**Lead Local Flood Authority
Ground Floor
Northleigh
County Hall
Chichester
West Sussex
PO19 1RH**

Planning Reference: **A/30/26/PL**

Site Address: **Highdown Garden Centre Littlehampton Road Ferring BN12 6PG**

Planning Description: **Demolition of existing open sided structures and erection of retail canopies and restaurant lobby. This application is in CIL Zone 3 (Zero Rated) as other development.**

Drawing No: A9803 - 140 P2

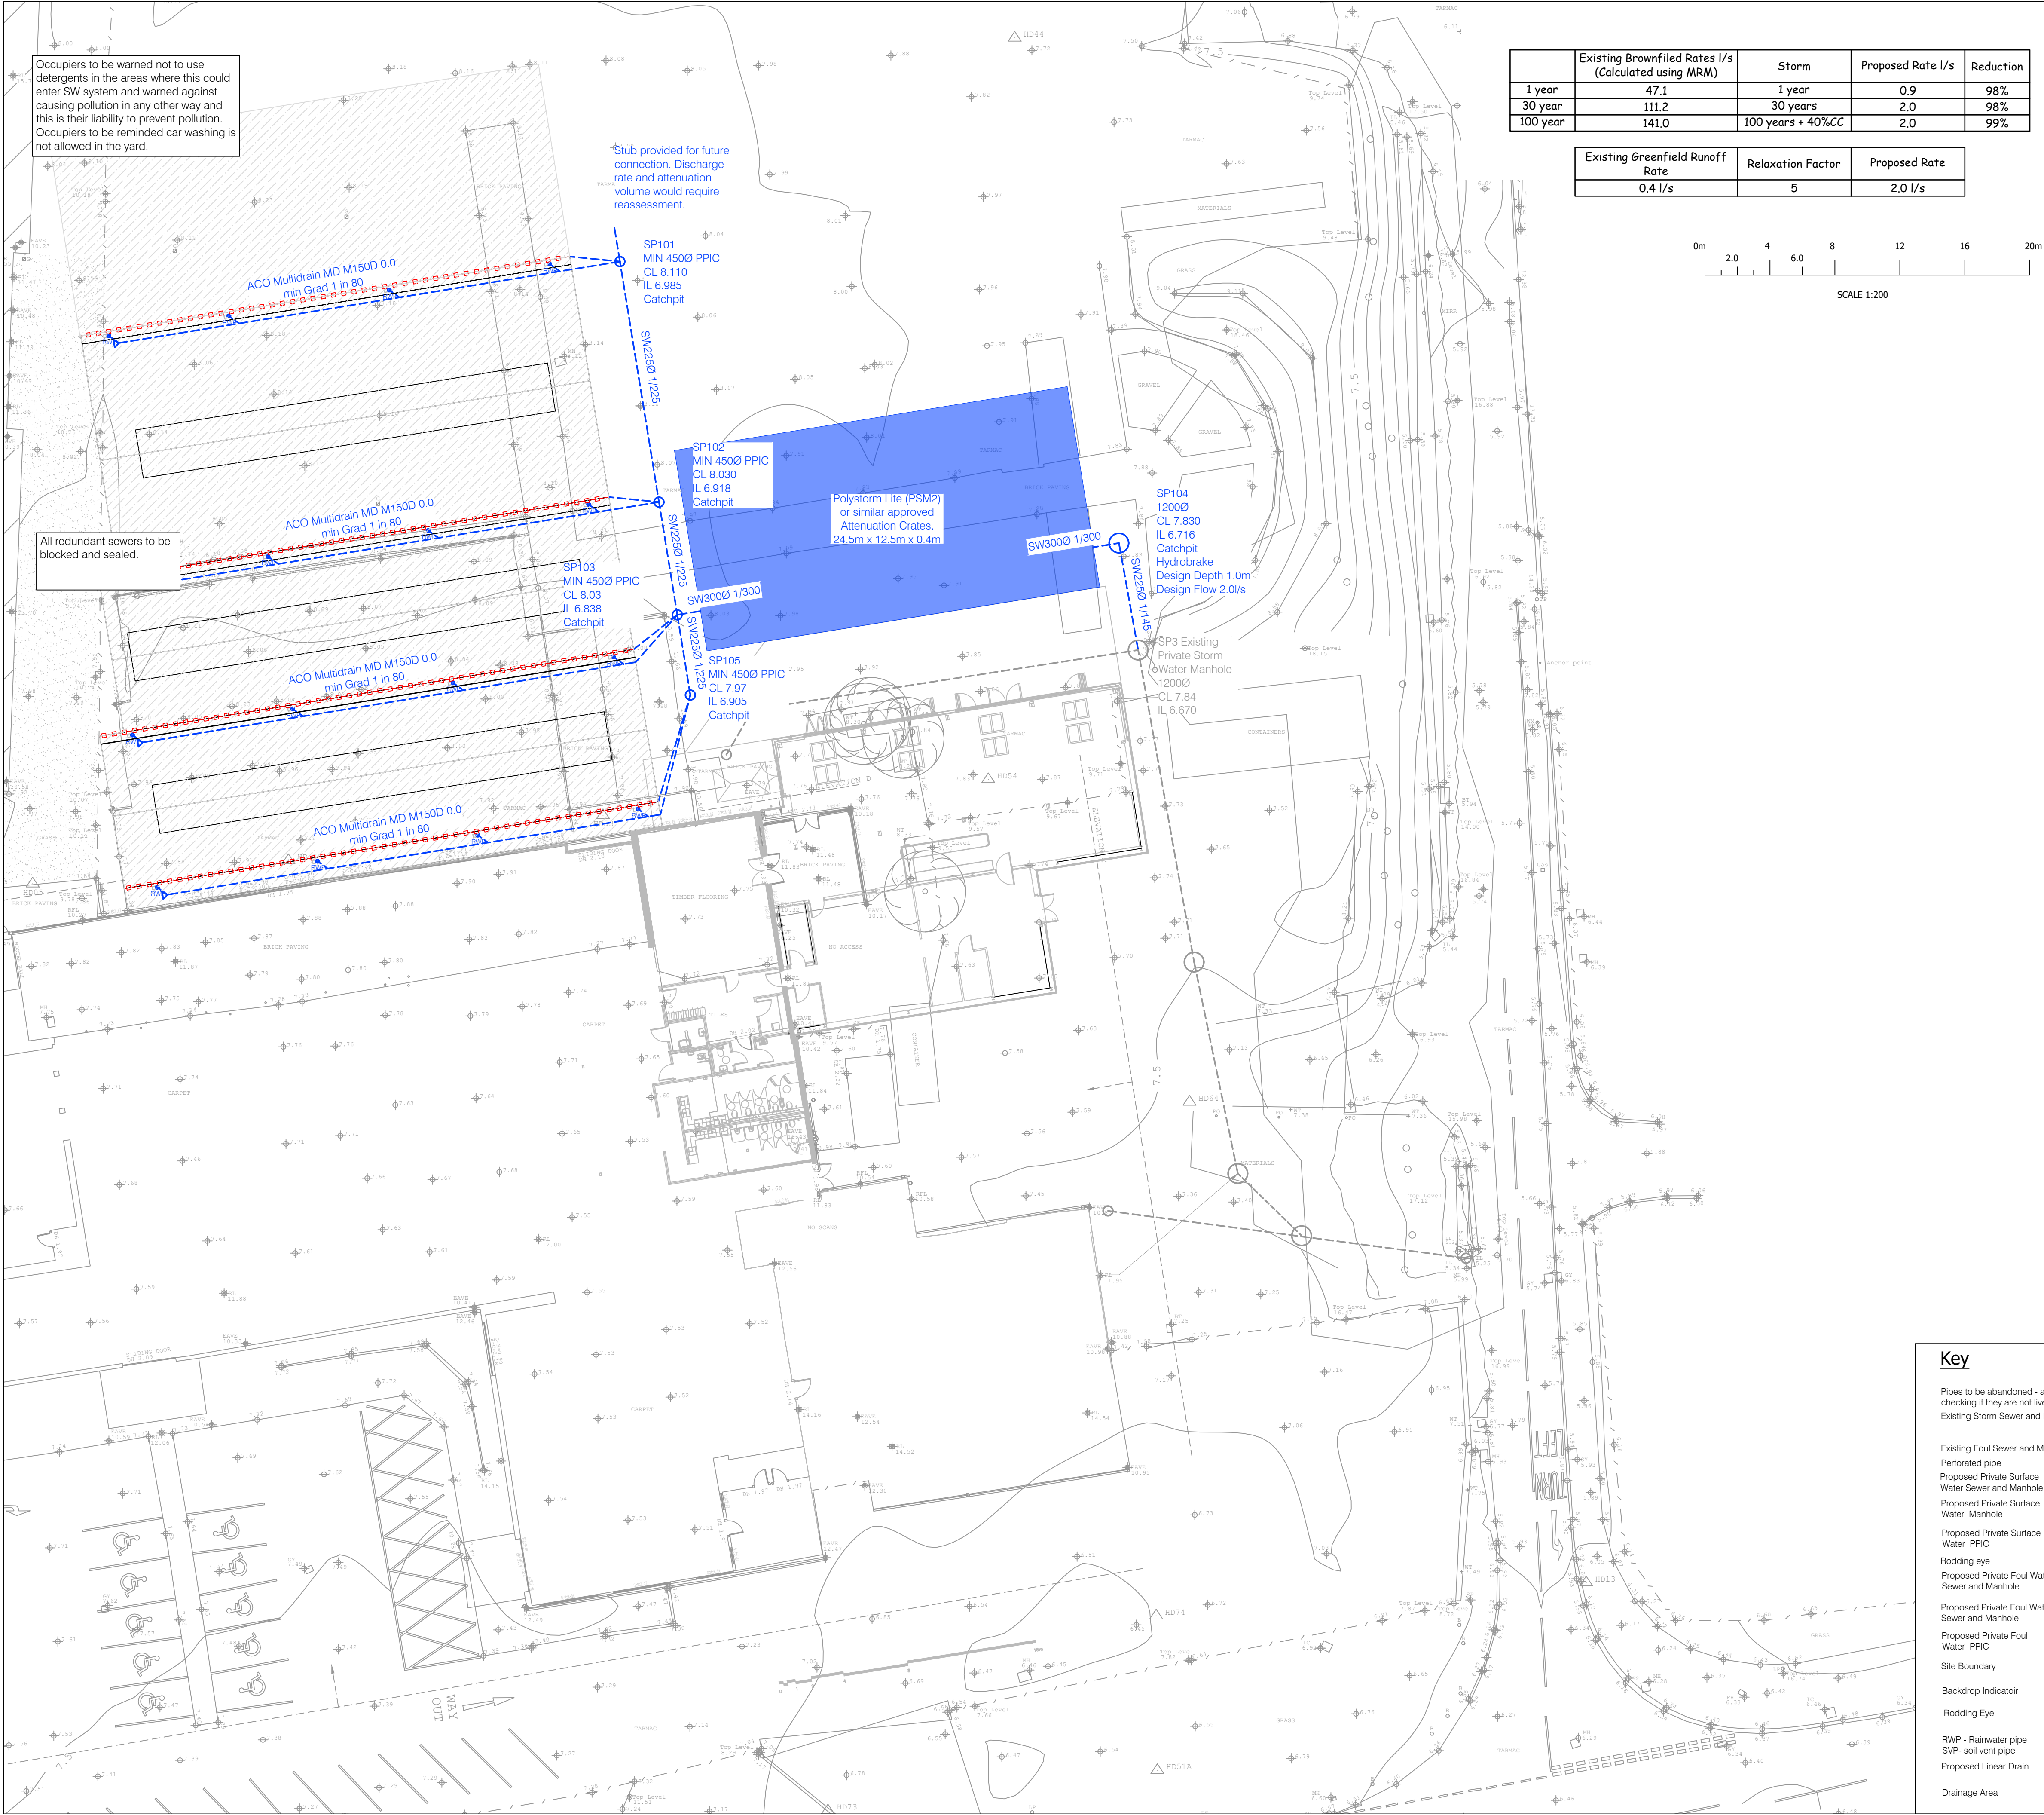
The proposed works are classed as major development and therefore the applicant must provide an appropriate site-specific Flood Risk Assessment and Drainage Strategy to support the application. While a drainage layout has been provided, this must be supported with a drainage strategy and calculations to ensure it is suitable and viable at the site.

3. The current proposals are to connect the new surface water drainage into the existing network. An assessment of the existing drainage and a CCTV survey is required to ensure the existing network is suitable for the proposed connection.
